RE: Blue Sky Short Plat (SP-10-00003)

The Kittitas County Community Development Services Department has determined that the Blue Sky Short Plat (SP-10-00003) is a complete application and hereby grants *conditional preliminary approval* subject to the following conditions:

SUBJECT: Blue Sky Short Plat SP-10-00003

BLUE SKY SHORT PLAT
A PORTION OF THE SOUTH 1/2 OF SEC. 29 T.20N., R.16E., W.M.
KITITAS COUNTY, WASHINGTON

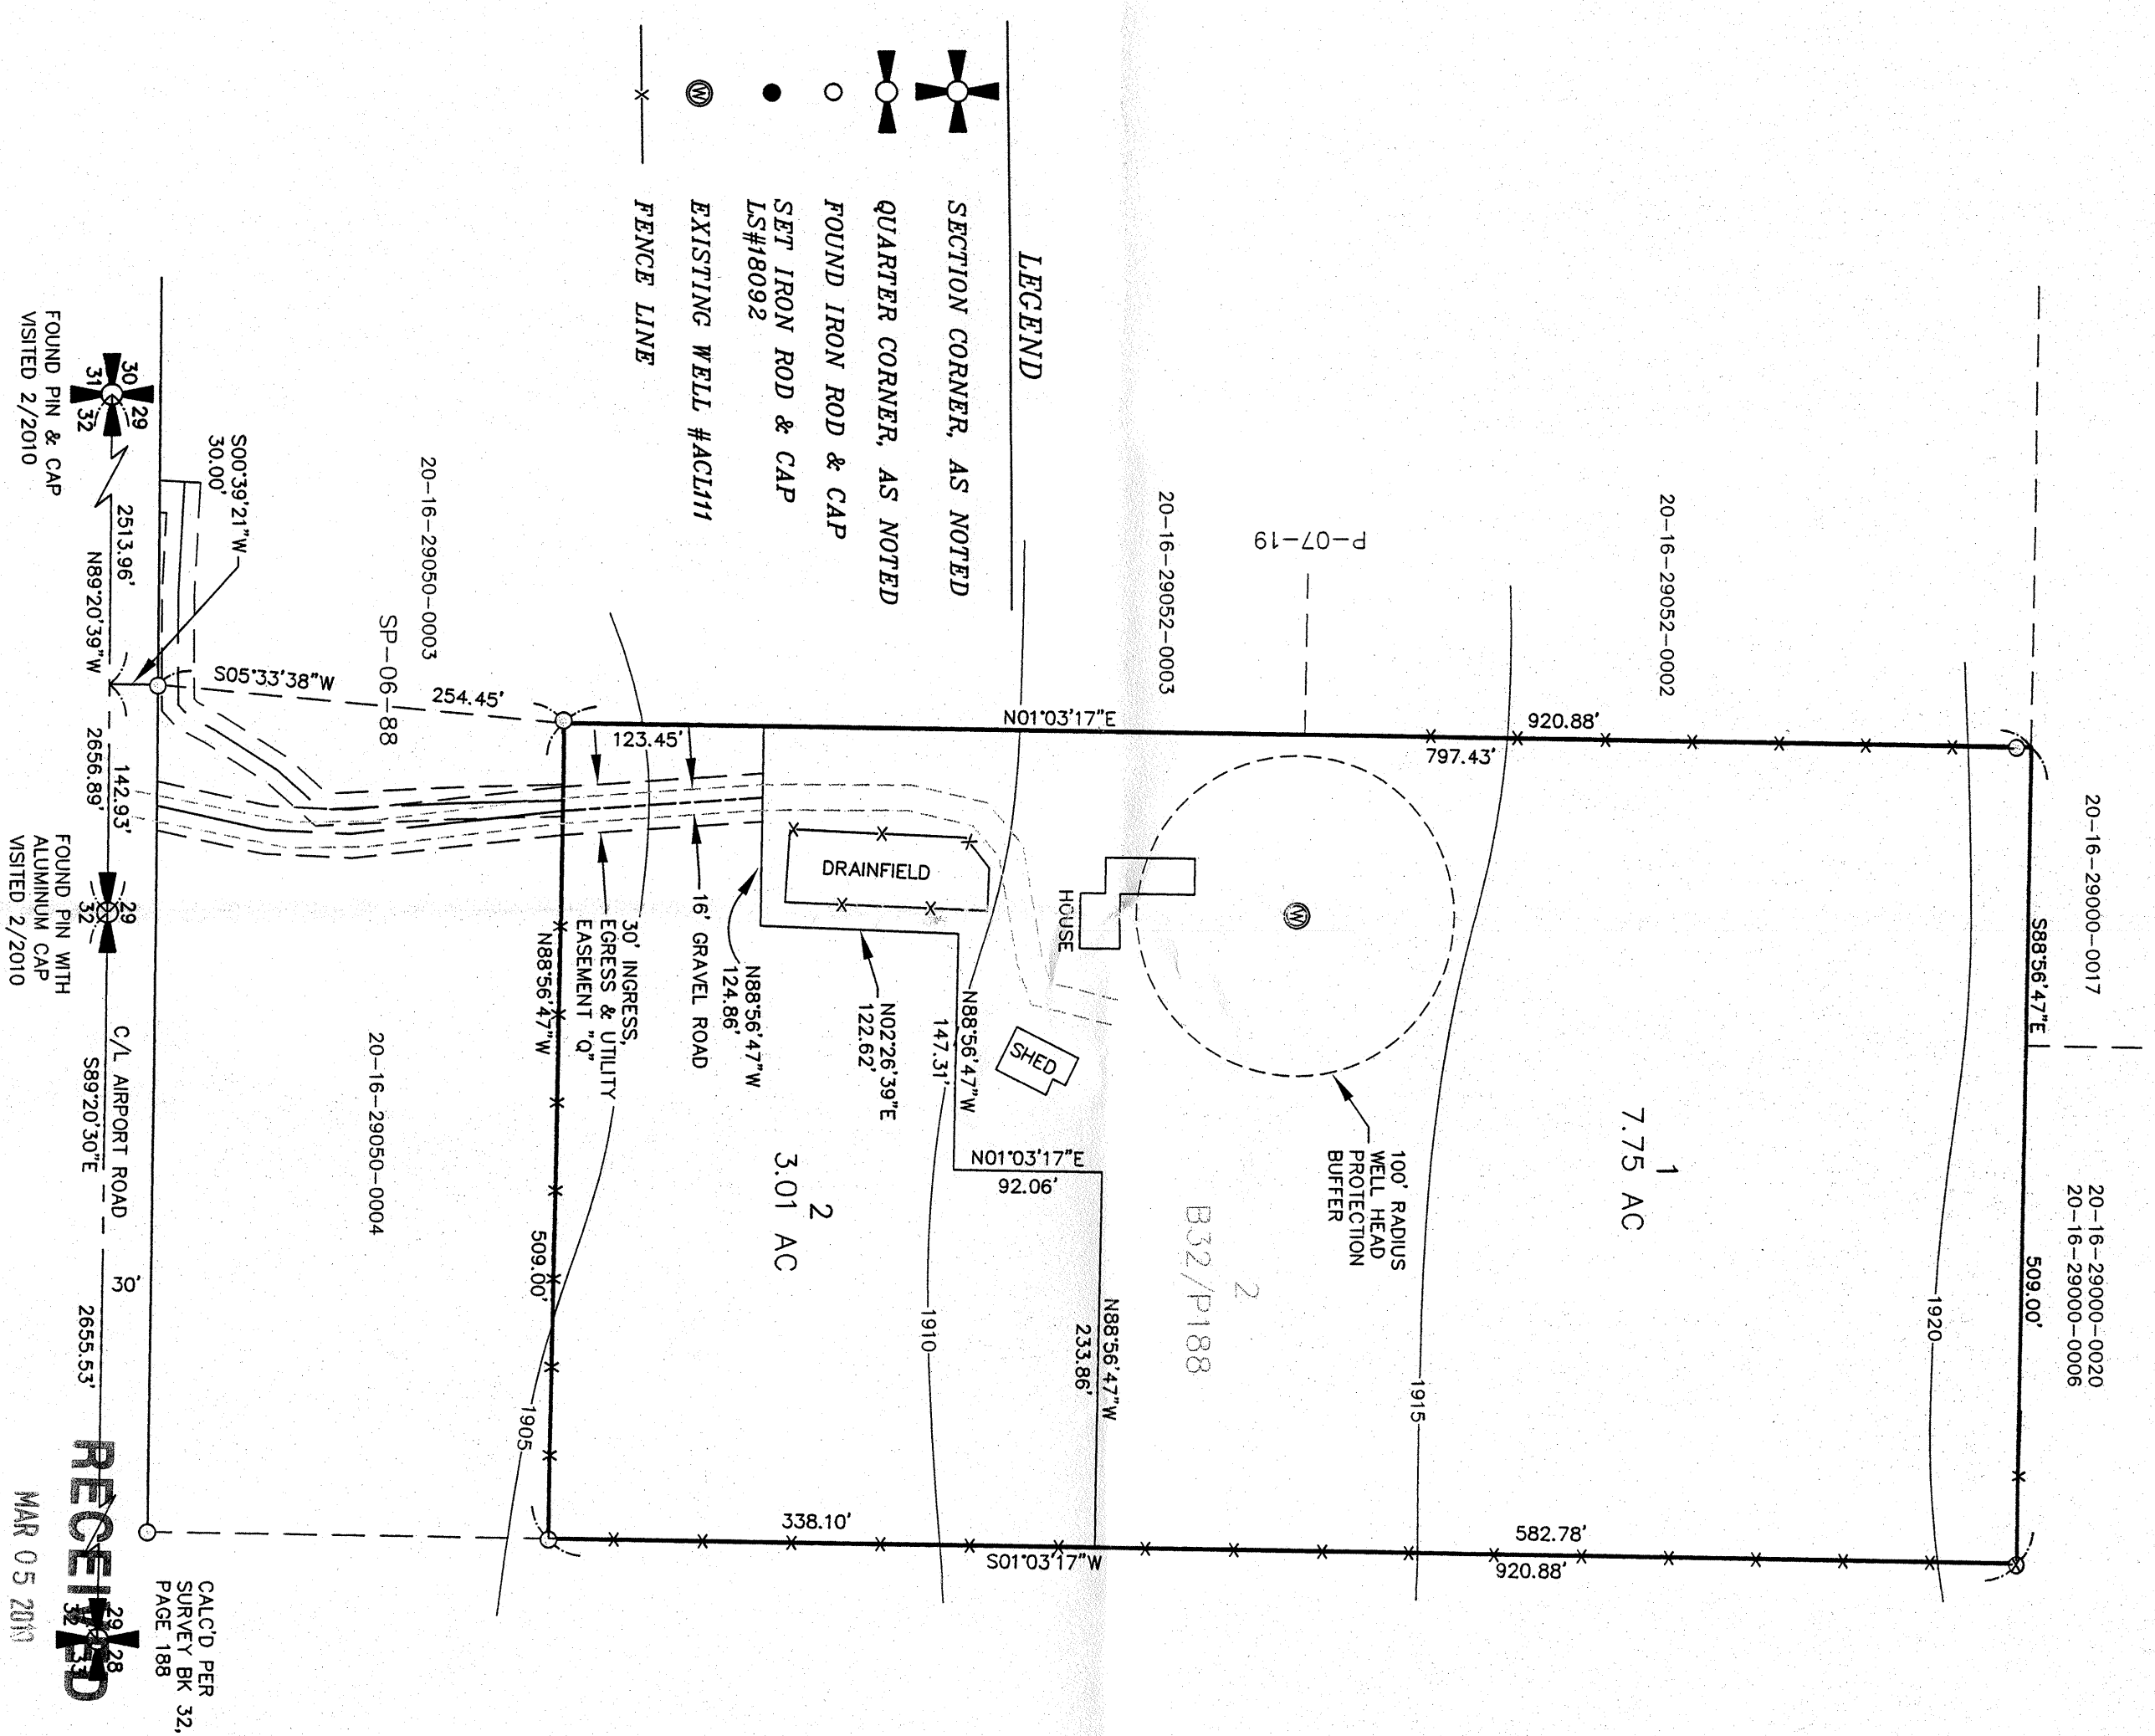
1. Both sheets of the final mylars shall reflect short plat number SP-10-00003 and an accurate legal description shall be shown on the face of the final plat.

4. Individual wells are required to have a 50 foot setback from neighboring property lines (KCC 17A.08.025).
5. Should ground disturbing or other activities related to the proposed short plat result in the inadvertent discovery of cultural or archaeological materials, work shall be stopped in the immediate area and contact be made with the Washington State DAHP. Work shall remain suspended until the find is assessed and appropriate consultation is conducted. Should human remains be inadvertently discovered, as dictated by Washington State RCW 27.44.055, work shall be immediately halted in the area and contact made with the coroner and local law enforcement in the most expeditious manner possible.

3. Variance: All conditions of Road Variance 09-10 shall be met, including the construction of a paved apron, 22' wide gravel road, and all other road standards requirements.

4. Private Road Improvements: Access from Airport Road to the cul-de-sac shall be constructed to meet or exceed the requirements of a High-Density Private Road that serves 3-14 tax parcels. See Kittitas County Road Standards, 9/6/05 edition.

- a. Access easements shall be a minimum of 40' wide. The roadway shall have a minimum width of 20', with 1' shoulders, for a total width of 22'.
 - b. Minimum centerline radius will be 60'.

5. Cul-de-Sac: A cul-de-sac turn-around having an outside right-of-way or easement diameter of at least 110 feet shall be constructed at the closed end of all dead-end roads serving 3 or more lots. The driving surface shall be at least 96 feet in diameter. Cul-de-sacs must also conform to the requirements specified by the 2006 International Fire Code. Contact the Fire Marshal regarding any additional cul-de-sac requirements.
